## OFFICER'S REPORT

APPLICATION NUMBER: S6/2003/1311/FP

LOCATION: Wyndham Cottage, Camfield Place, Essendon

PROPOSAL: Erection of two storey side extension and rear conservatory

CONSENT  
 - 1 SEP 2003  
 NO. 03/1311/17

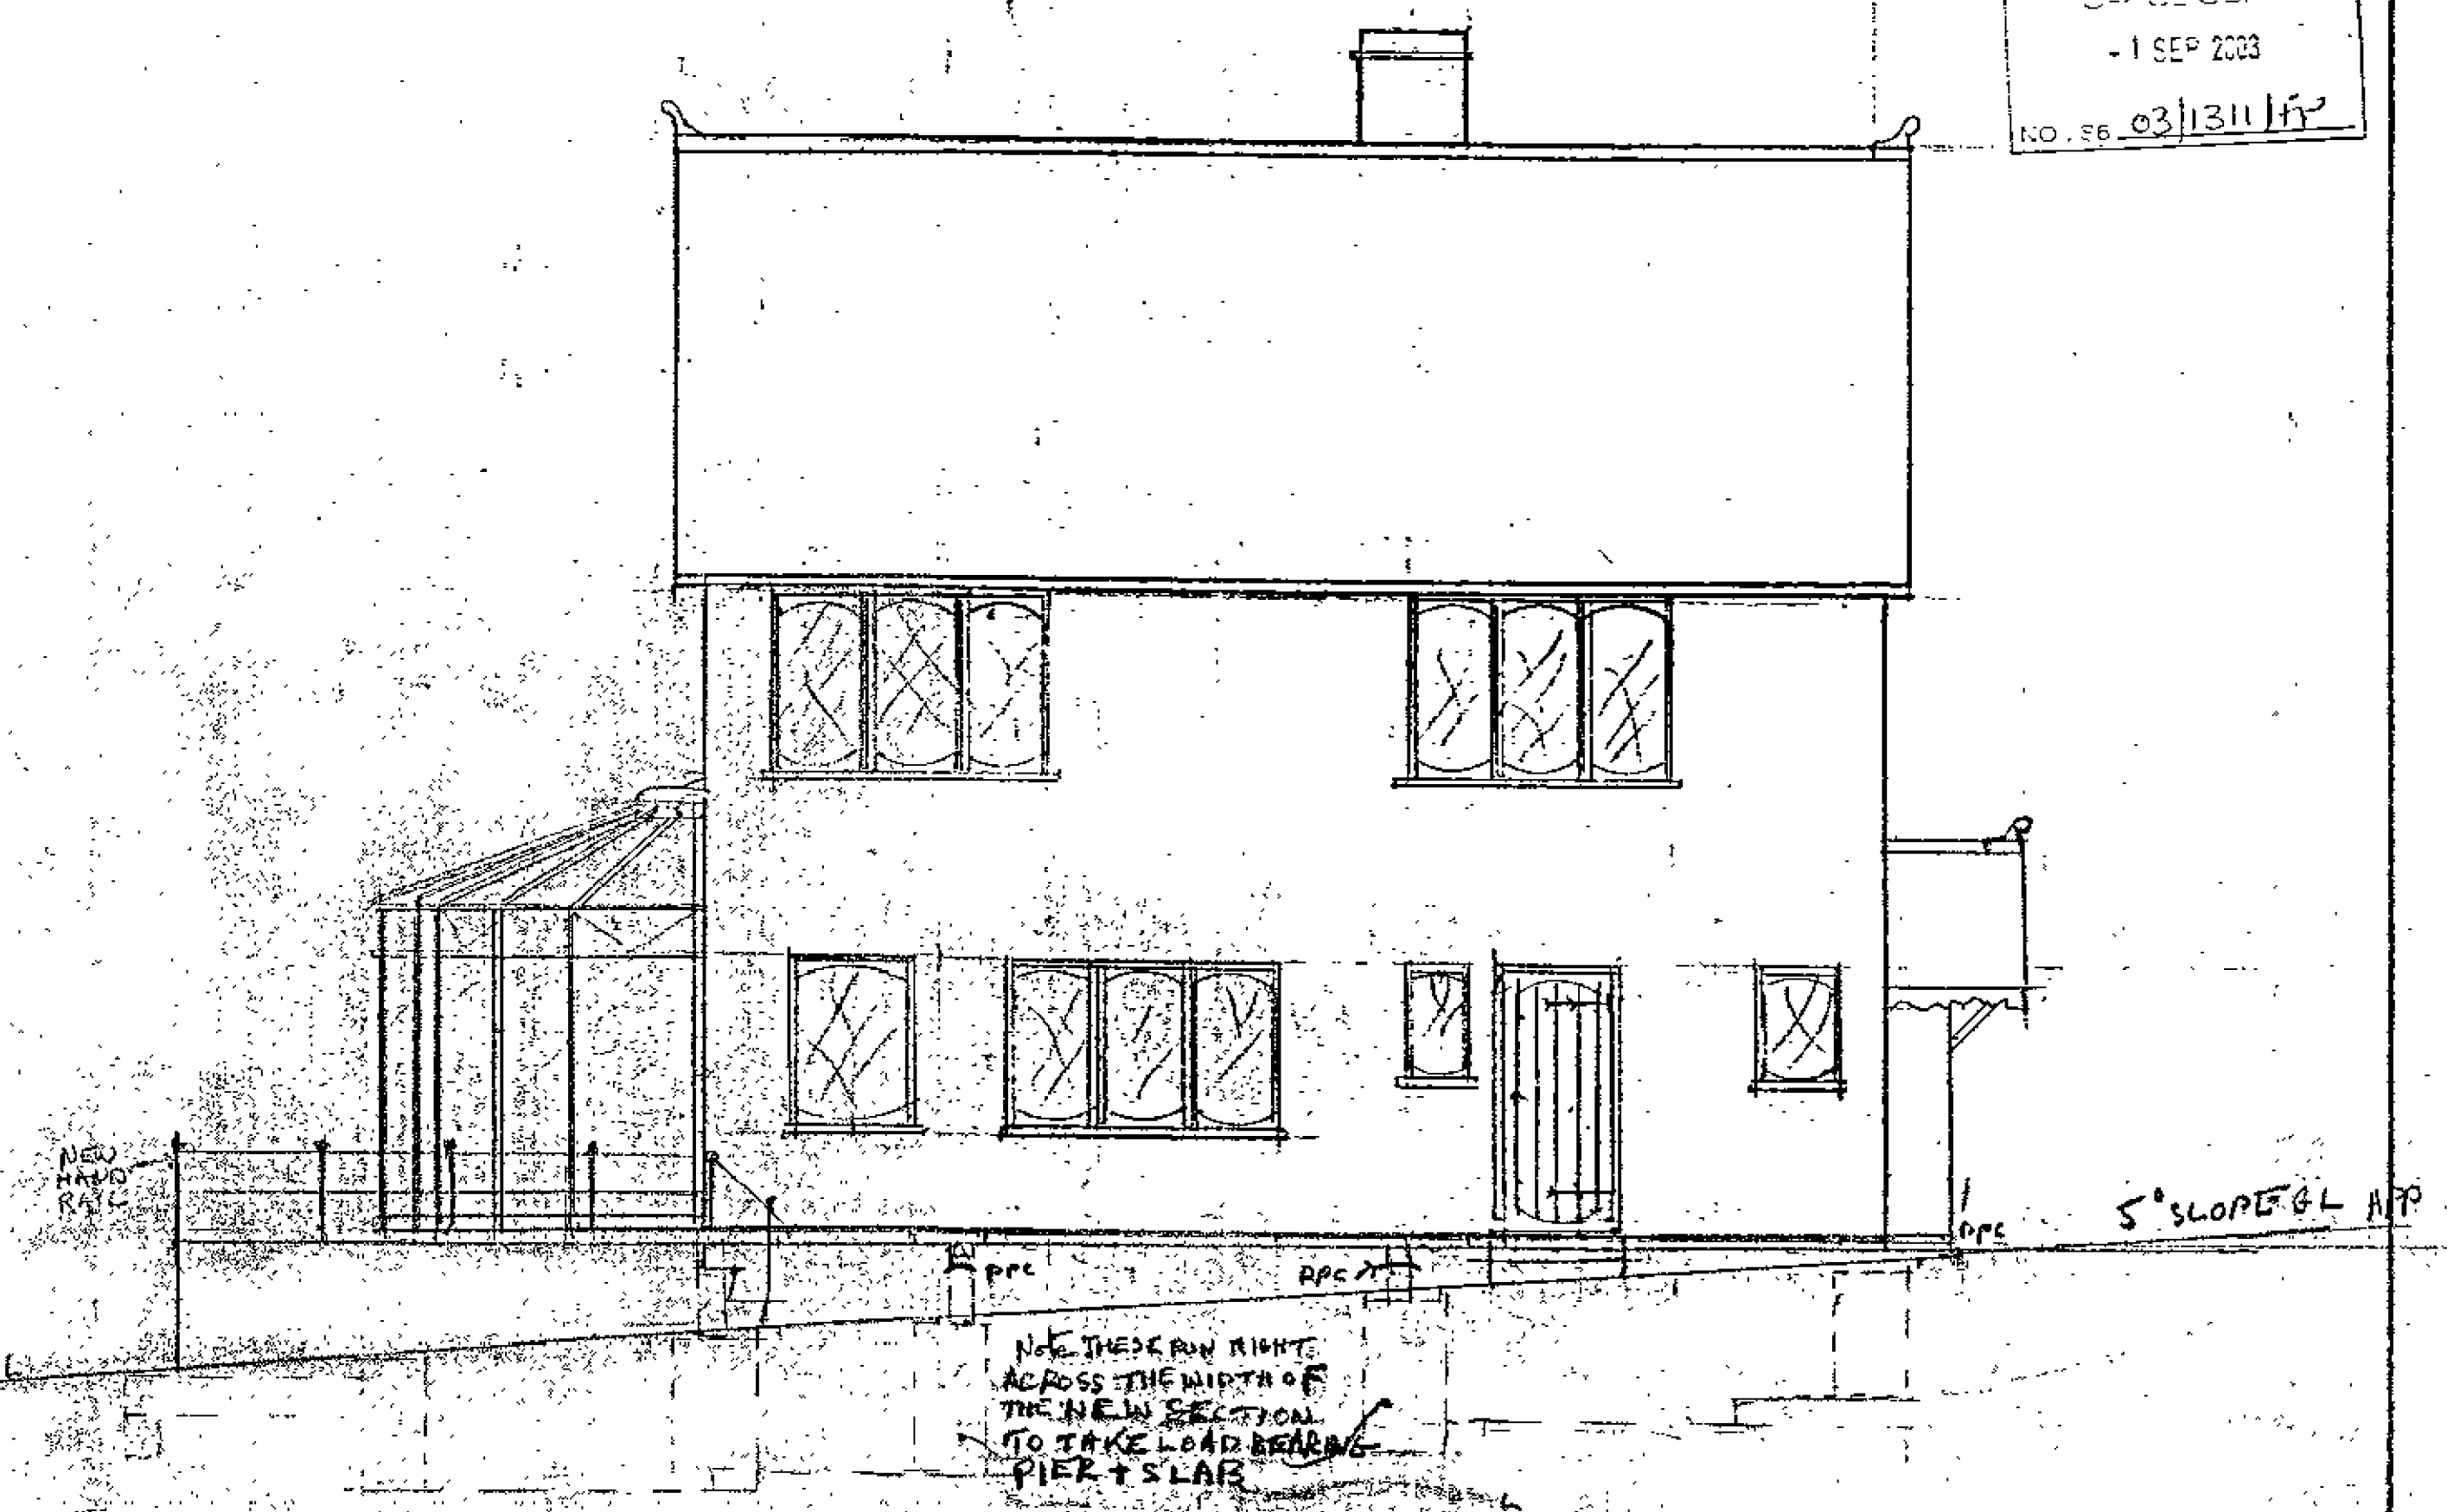
The proposals have been assessed in terms of policy GB3 and GB5. The garage and green house buildings, although not an extension have already substantially increased the built form in this rural location. The proposed extension will add further to the dwelling itself. The extensions proposed, particularly when viewed in association with the garage are disproportionate to the size of the original dwelling. When considered alone they represent a 67% increase, however if including the garage and glasshouse as well it would represent a floorspace increase of 109%. The site is well screened from the road and surrounding area and therefore no adverse visual impact will result. In terms of the size and bulk however the proposals do not accord with policy GB3, GB5, RA1 or RA3.

In terms of the Council's Residential Criteria, the application is also not acceptable. The extension would not be subordinate to the original dwelling and does not reflect the design or character of the house through the introduction of a gabled roof. The extension would also visually unbalance the appearance of the dwelling. Due to its isolated location and position away from the road the extension will accord with all other aspects of this policy.

1. The proposed extensions will result in a disproportionate increase in the size and bulk of the original dwelling and as such will harm the openness of the Green Belt contrary to policies GB3 and GB5 of the Welwyn Hatfield District Plan, Alterations No. 1, adopted March 1998 and policies RA1 and RA3 of the Welwyn Hatfield District Plan Review, Revised Deposit Version, published June 2002.
2. The proposed extensions are not subordinate to the original house and do not reflect the design or character of the original dwelling and as such will harm the appearance of the dwelling contrary to the requirements of policy Res Criteria 22 of the Welwyn Hatfield District Plan, Alterations No. 1, adopted March 1998 and Supplementary Design Guidance, Welwyn Hatfield District Plan Review, Revised Deposit Version, published June 2003.
